DRB Application No.: 03DRB-00092 (SBP)	Project # 1002435
Project Name: NORTH ALBUQ. ACRES UNIT B	EPC Application No.:
Agent: Dekker Perich Sabatini	Phone No.: 761-9700

CITY OF ALBUQUERQUE
Planning Department
Development Review Board Case Comments
1/29/03

Case # 03DRB-00092

Subject: North Albuquerque Acres, Unit B/ SDP for BP

D1 MONUMENT SIGNAGE
1/4" = 1'-0"

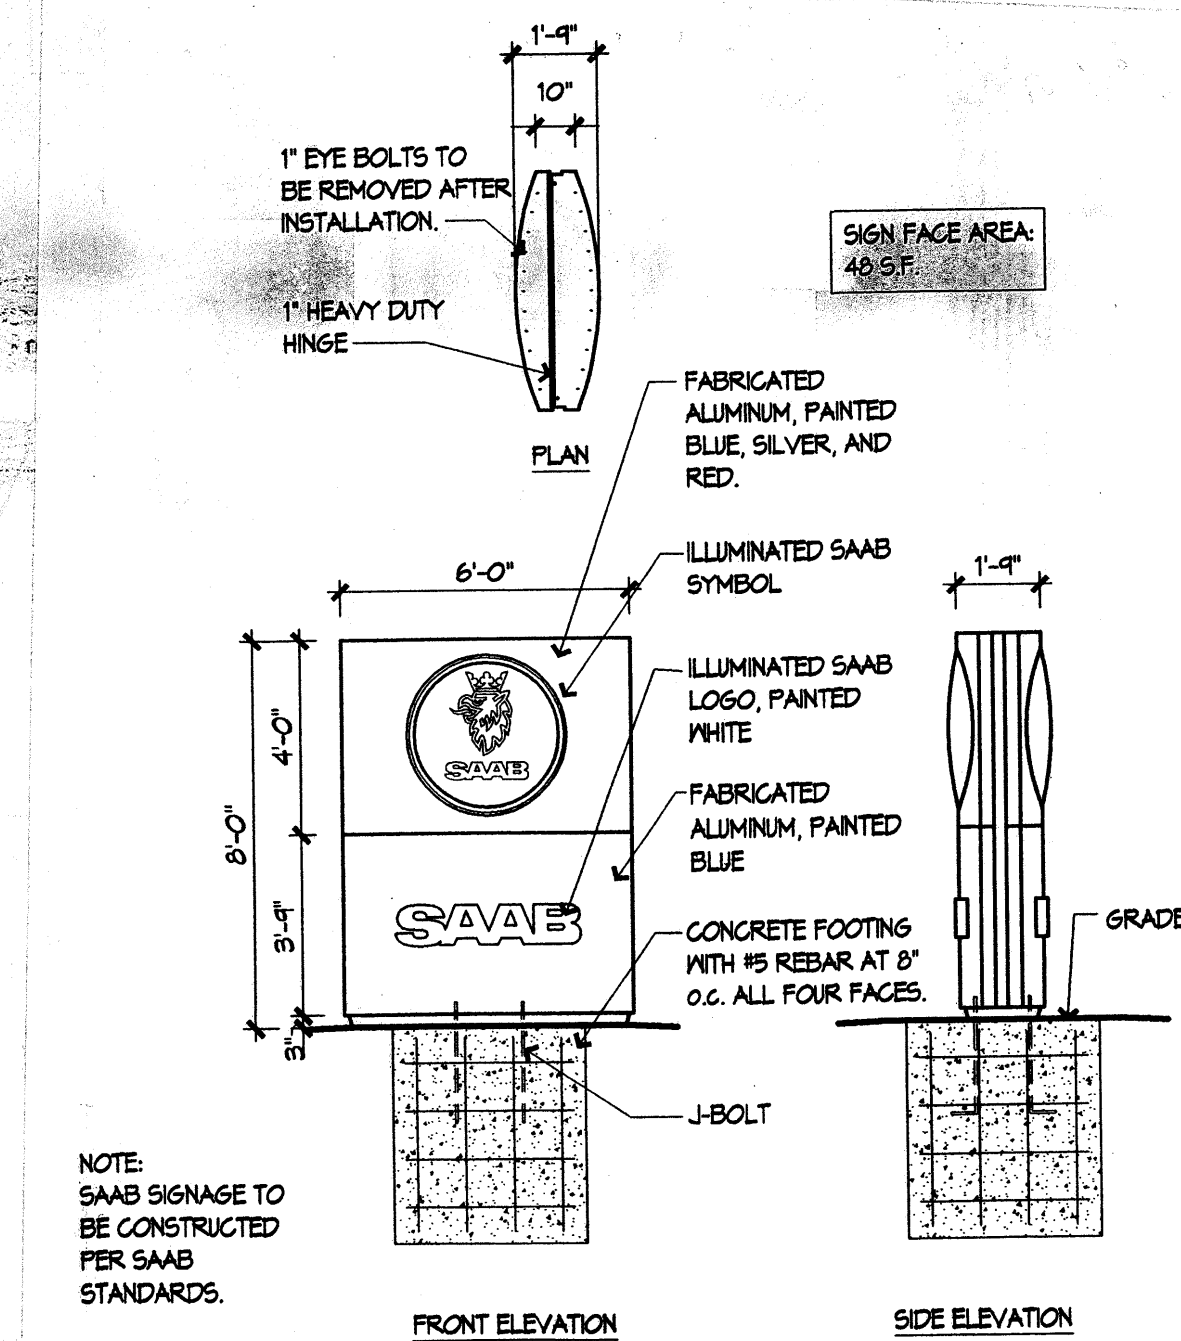
Page 28 of the Alameda Boulevard Design Overlay Zone specifies a maximum of 48 square feet and height of 8 feet for monument signs in Character Zone 4, within which this property lies. The current sign shown on the site plan exceeds both of these requirements.

SITE PLAN
1" = 20'-0"

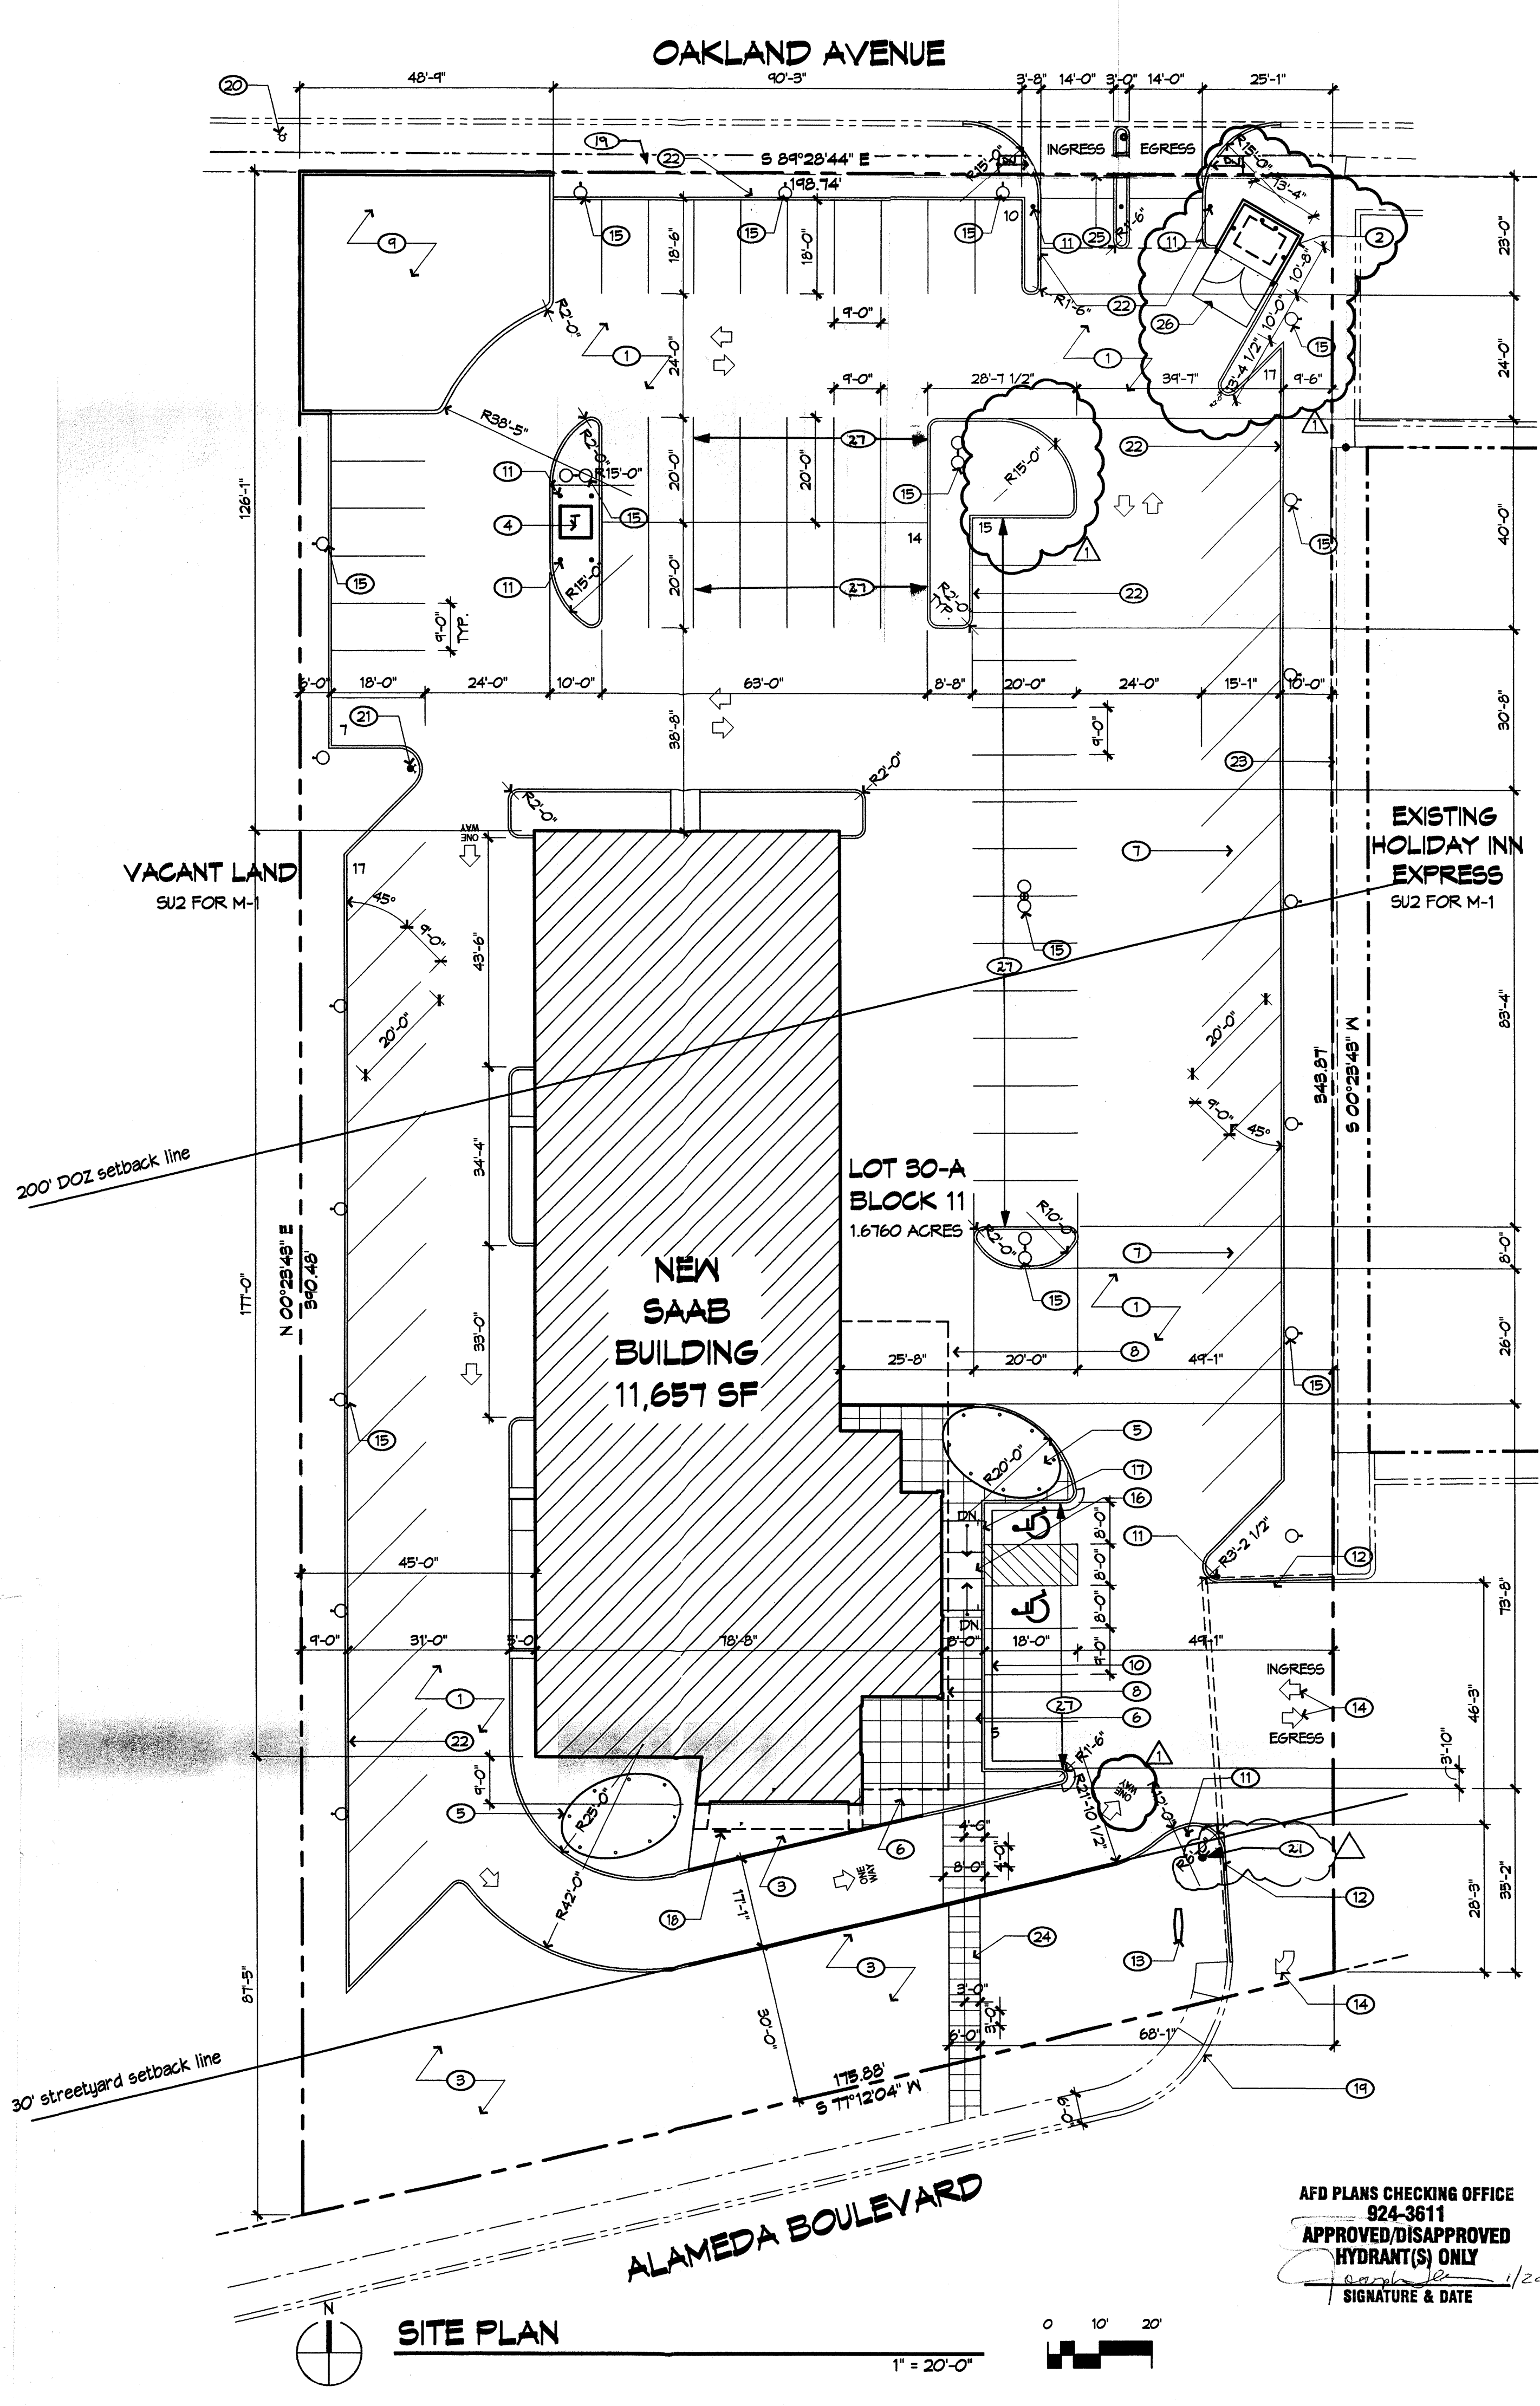
TRANSPORTATION: Show SPURKS on OAKland w/ H.C. RAMPs @ Entrance
 Cross Access EASEMENT

No.	Comment
<input type="checkbox"/>	The cross-access easement needs to be documented.
<input type="checkbox"/>	Call-out customer parking and display parking, if applicable.
<input type="checkbox"/>	Is Oakland improved, including sidewalk?

This property lies within 1000' of a landfill. Therefore, the landfill disclosure statement must be placed on the site plan prior to final signoff. Applicant will need to contact EHD to send Planning an e-mail stating if the disclosure statement is sufficient in this case. If not, the project may need to be deferred until this issue is satisfied to the satisfaction of EHD.

The revised site plan submitted 1/24/03 showing the trash receptacle in a new location has a problem. The former location of the dumpster now needs a 15' turning radius according to Transportation Development.

CONCEPTUAL
GRADING,
DRAINAGE, &
UTILITY PLAN

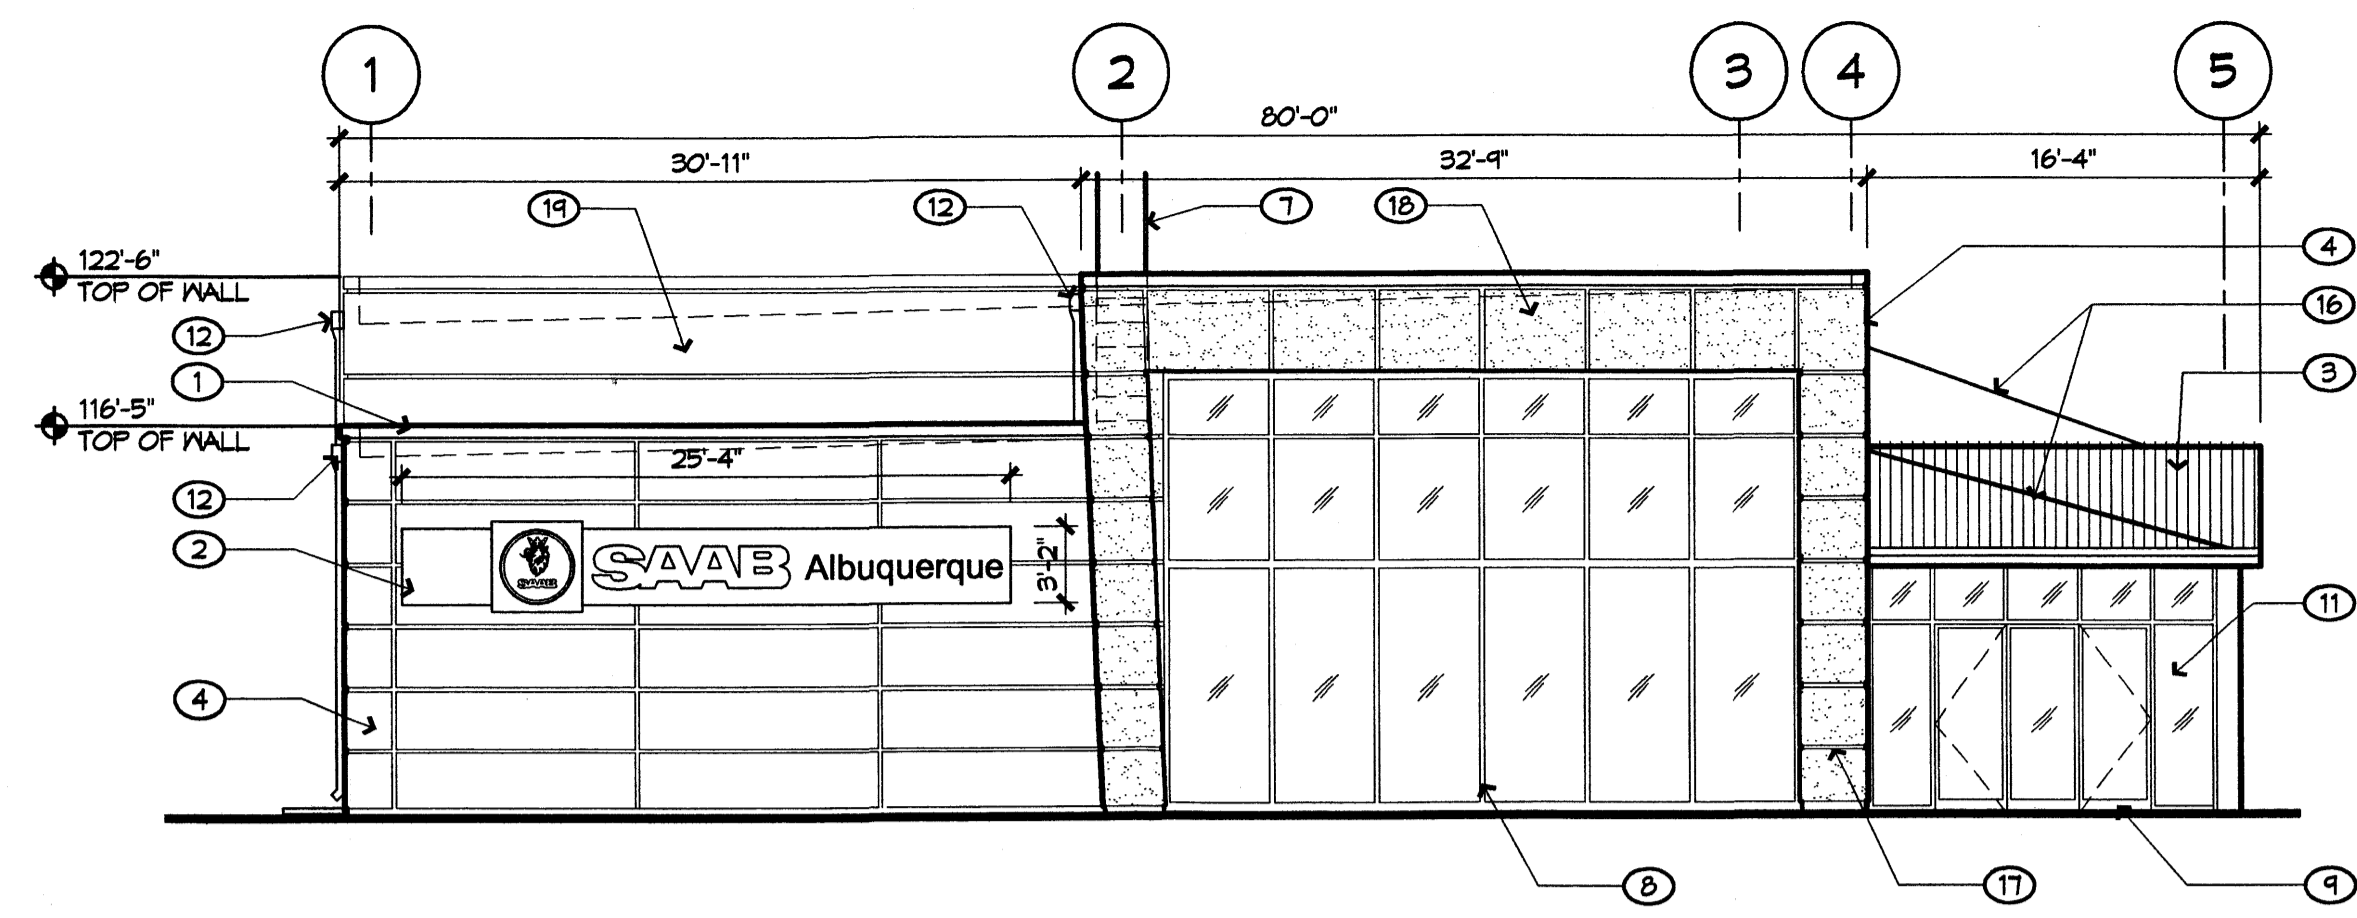
UTILITIES:
 Resolve Fire Hydrant connections / Coverage.
